**Consultation Response from KC,
Lead Local Flood Authority**
2020/93650 Former North Bierley Waste Water Treatment Works, Cliff Hollins Lane, Oakenshaw, BD12 7ET
Discharge of Condition 3 (access road). Condition 4 (internal estate road) and Condition 5 (landscape works) of previous permission no. 2020/91488 for reserved matters application pursuant to application no. 2016/92298 for outline application for re-development of former waste water treatment works following demolition of existing structures to provide employment uses (use classes B1(c), B2 and B8)
Date Responded: 27/03/2023.
Responding Officer: Martin Stephenson
Responding Ref: 1
Previous response by the LLFA

Discharge of Drainage Conditions

- No. 4 (internal estate road)

SECTION 2
SCALE - 1:25 @ A1

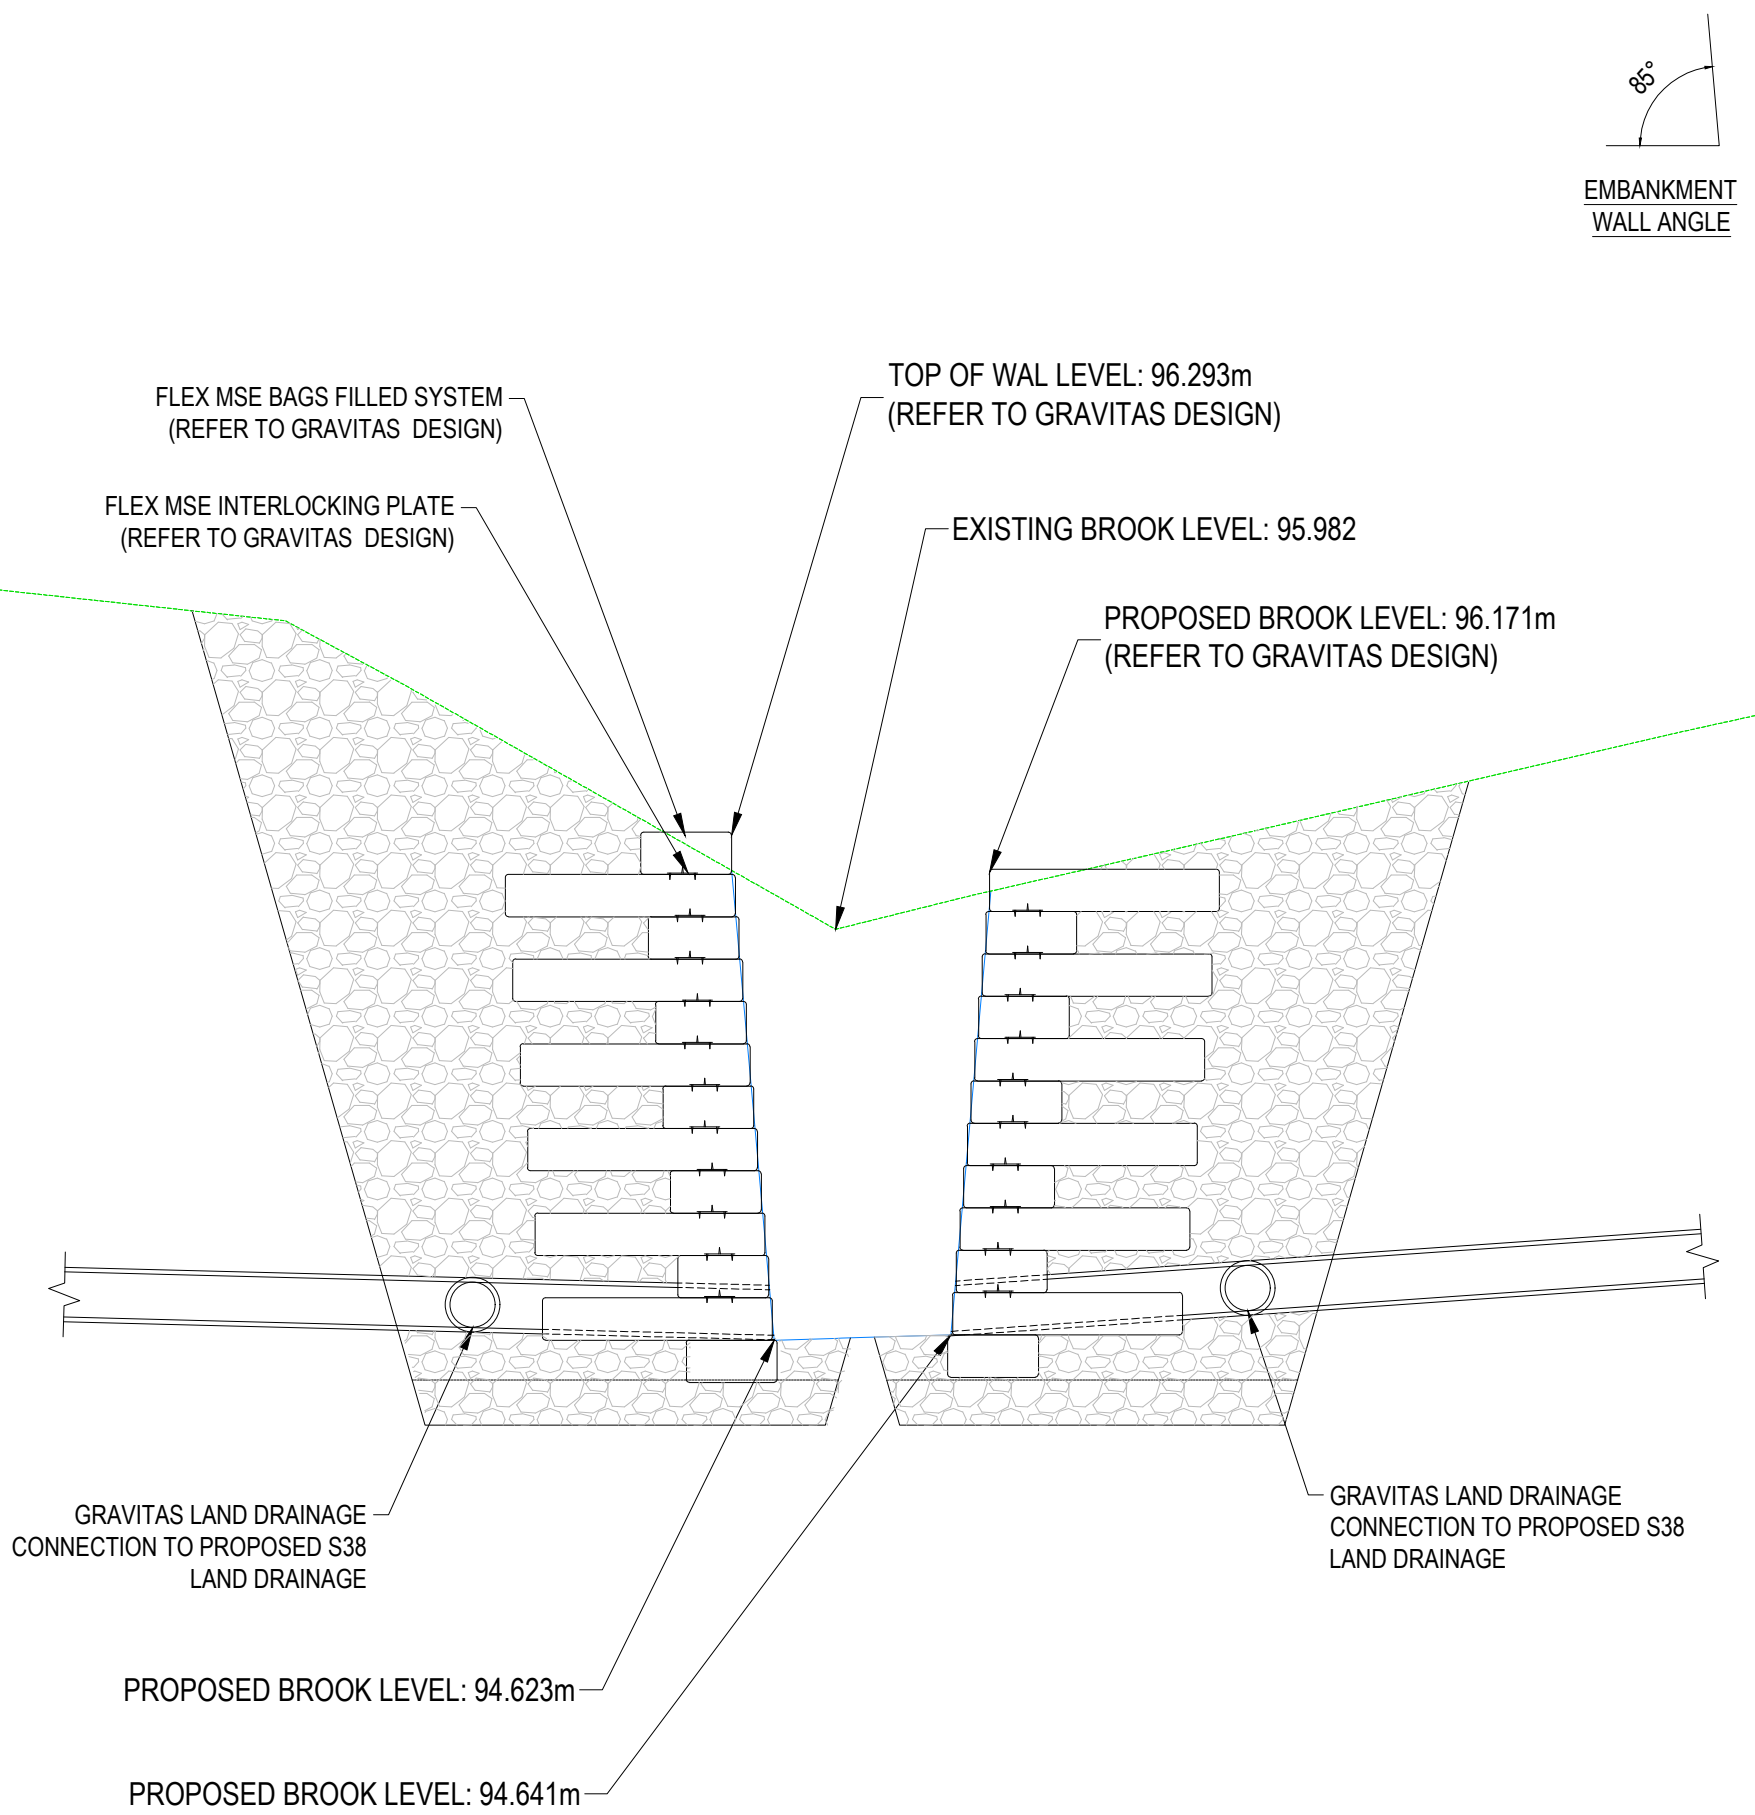
With regard to the S38 Reprofiled Brook Diversion drawing, the discharge of condition is also the responsibility of the S38 team. Note, however the reprofiling of an existing watercourse is subject to a Land Drainage Consent which can be applied for by the developer via the Kirklees Council website (<https://www.kirklees.gov.uk/beta/flooding-and-drainage/work-on-watercourses.aspx>).
